**EL PASO COUNTY PLANNING AND  
 COMMUNITY DEVELOPMENT  
 DEPARTMENT**

**STORMWATER MANAGEMENT PLAN CHECKLIST**

EC02

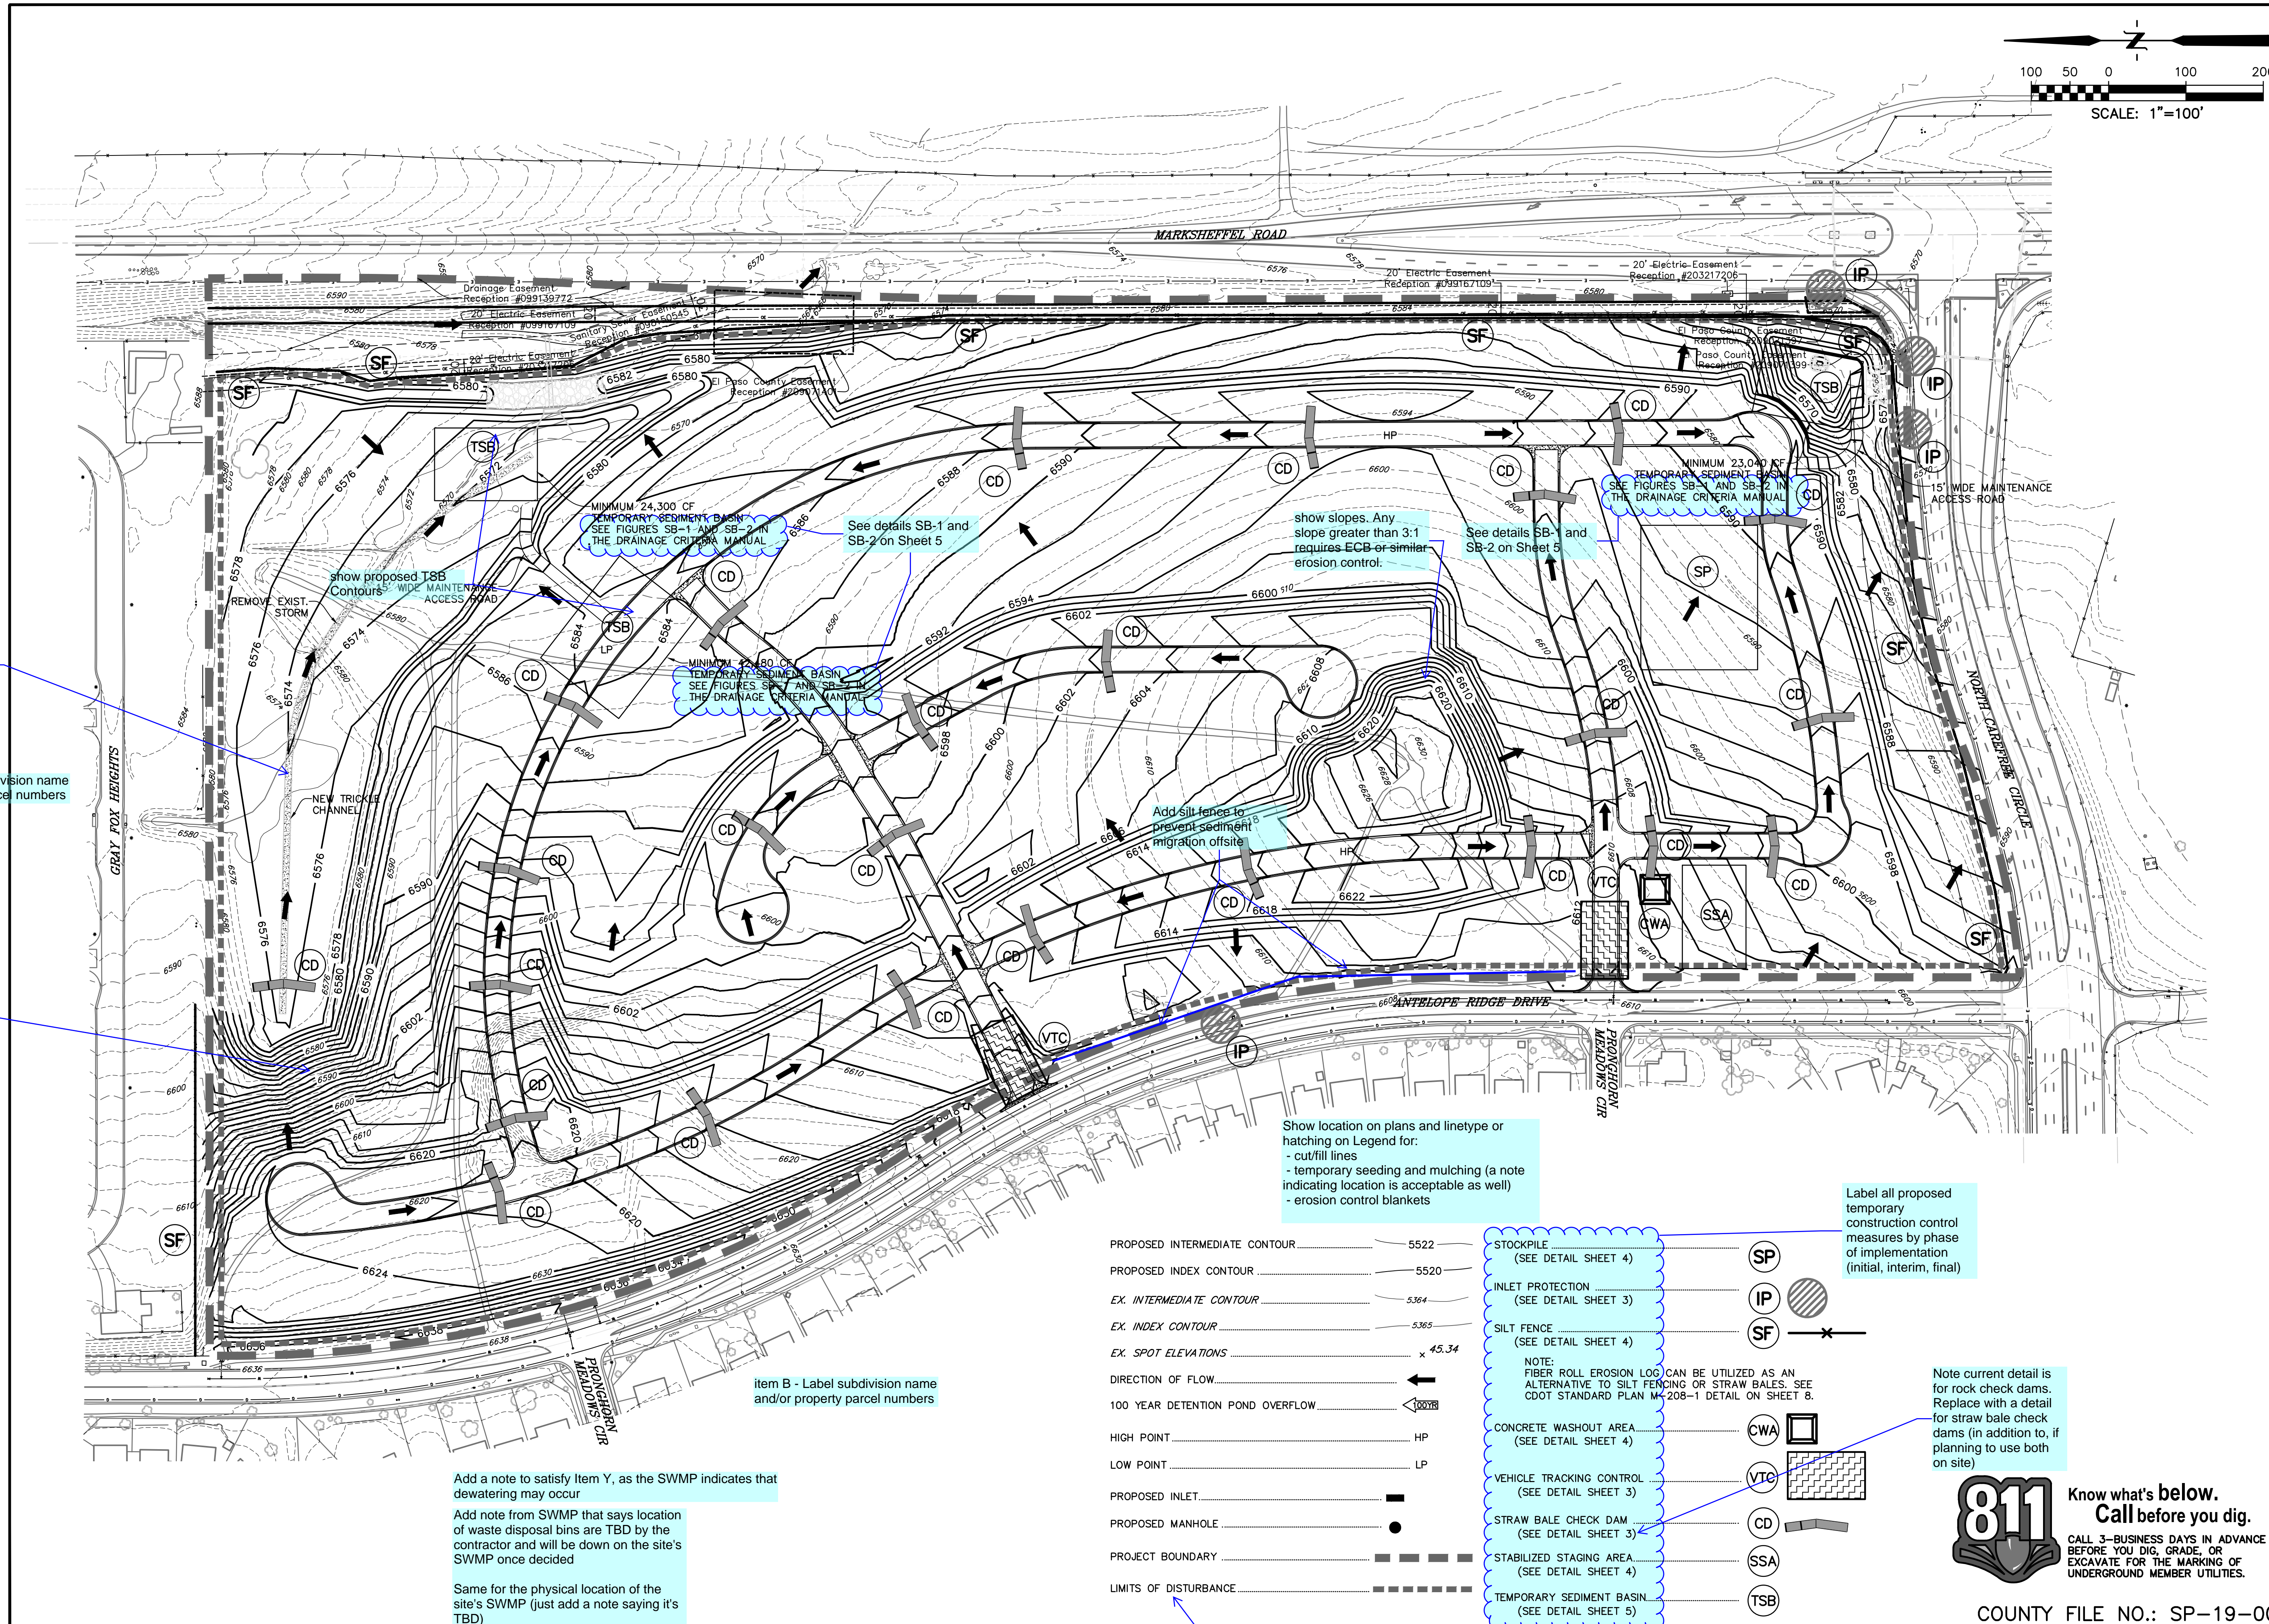
Revised: July 2019		Applicant	PCD
17	SWMP Map to include:	X	
17a	construction site boundaries	X	X
17b	flow arrows to depict stormwater flow directions	X	✓
17c	all areas of disturbance	X	✓
17d	areas of cut and fill	X	X
17e	areas used for storage of building materials, soils (stockpiles) or wastes	X	✓
17f	location of any dedicated asphalt / concrete batch plants	N/A	✓
17g	location of all structural control measures	X	✓
17h	location of all non-structural control measures	X	X
17i	springs, streams, wetlands and other surface waters, including areas that require maintenance of pre-existing vegetation within 50 feet of a receiving water	N/A	✓
18	Narrative description of all structural control measures to be used. Modifications to EPC standard control measures must meet or exceed County-approved details.	X	X
19	Description of all non-structural control measures to be used including seeding, mulching, protection of existing vegetation, site watering, sod placement, etc.	X	✓
